**RECORD OF MEETING  
NOTES FOR ATTENDEES:**

GANSW 2<sup>nd</sup> PRE-LODGEMENT MEETING - 27.02.18  
Department of Planning – 320 Pitt St, Sydney

SSD 8989 – MEDOWIE CATHOLIC COLLEGE

LANDSCAPE MASTER PLAN

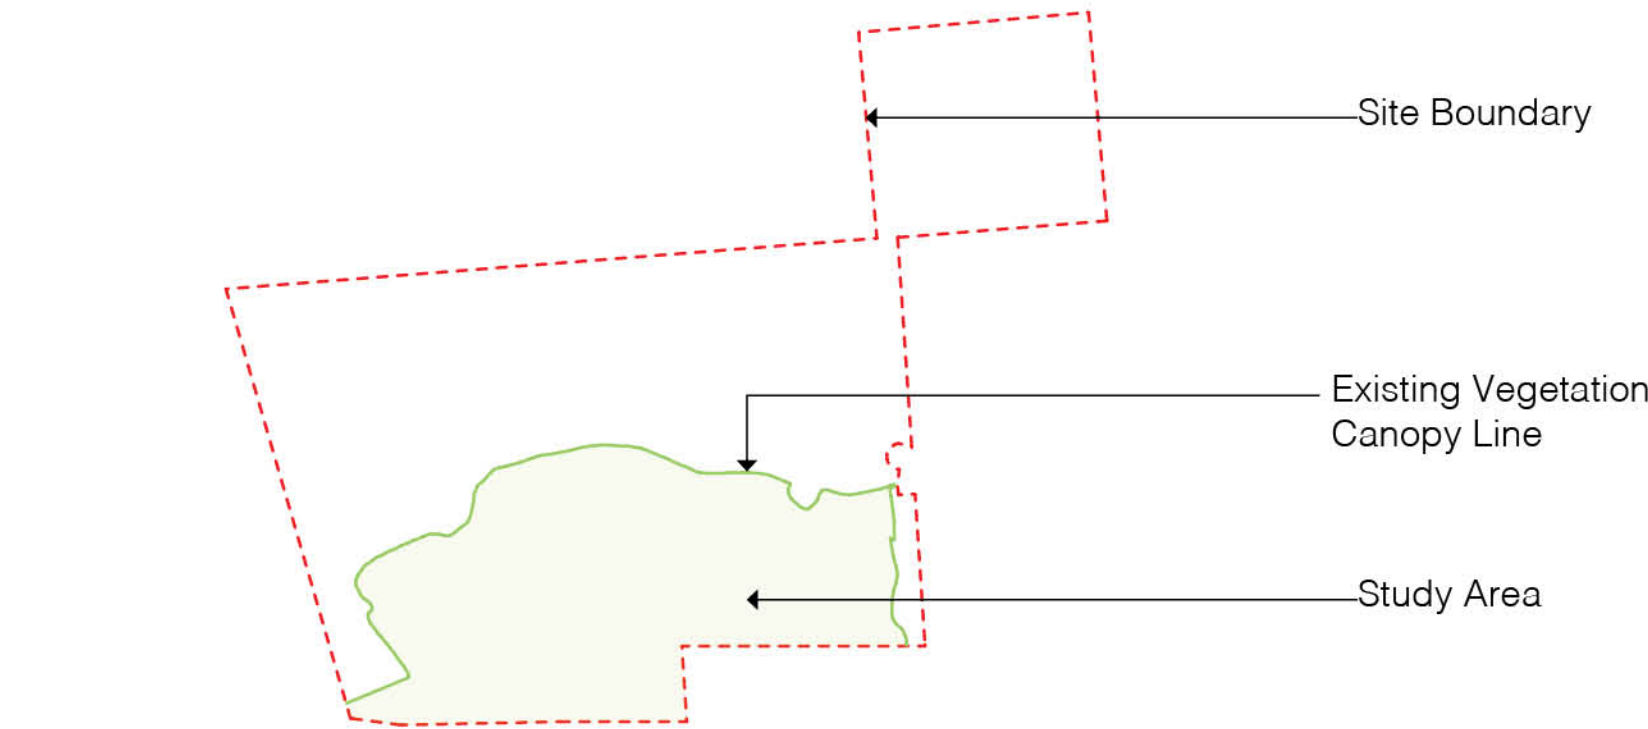
GANSW supports the efforts of the proponent and design team to improve the pedestrian focus and amenity of the streetscape, parking and entry strategy through engagement with RMS and the development of a series of options. Bus and drop-off locations are improved, pedestrian access is also improved though is not yet ideal. Bulk parking and landscape strategies require further development. We encourage the proponent to continue consultation with RMS and local council to seek further improvements. The proposal presented at the first pre-lodgement meeting indicated pedestrian access crossing both the parking and drop off queuing zones. The latest strategy shows a distinct pedestrian entry with crossing removed from the bulk of the traffic load.

- Continue to develop site planning in relation to car parking, drop-off bays, and vehicular entry to ensure that pedestrian access is safe and welcoming, including continued engagement with RMS and local council to review the location of the proposed intersection
- Consider relocating parking at the front of the school to other less prominent locations to reduce its visual impact and heat load
- Develop a landscape plan that reflects the rural area and softens the impact of the parking, queuing and drop off zones, for example through the introduction of permeable pavers, swales, trees interspersed between parking spaces, non-bitumen roadway/parking treatments, etc.
- Consider bollards or low gates at car park entry to preclude out-of-hours access by vehicles
- Accommodate drop-off locations along the ELC access
- Provide a Traffic Management Plan.
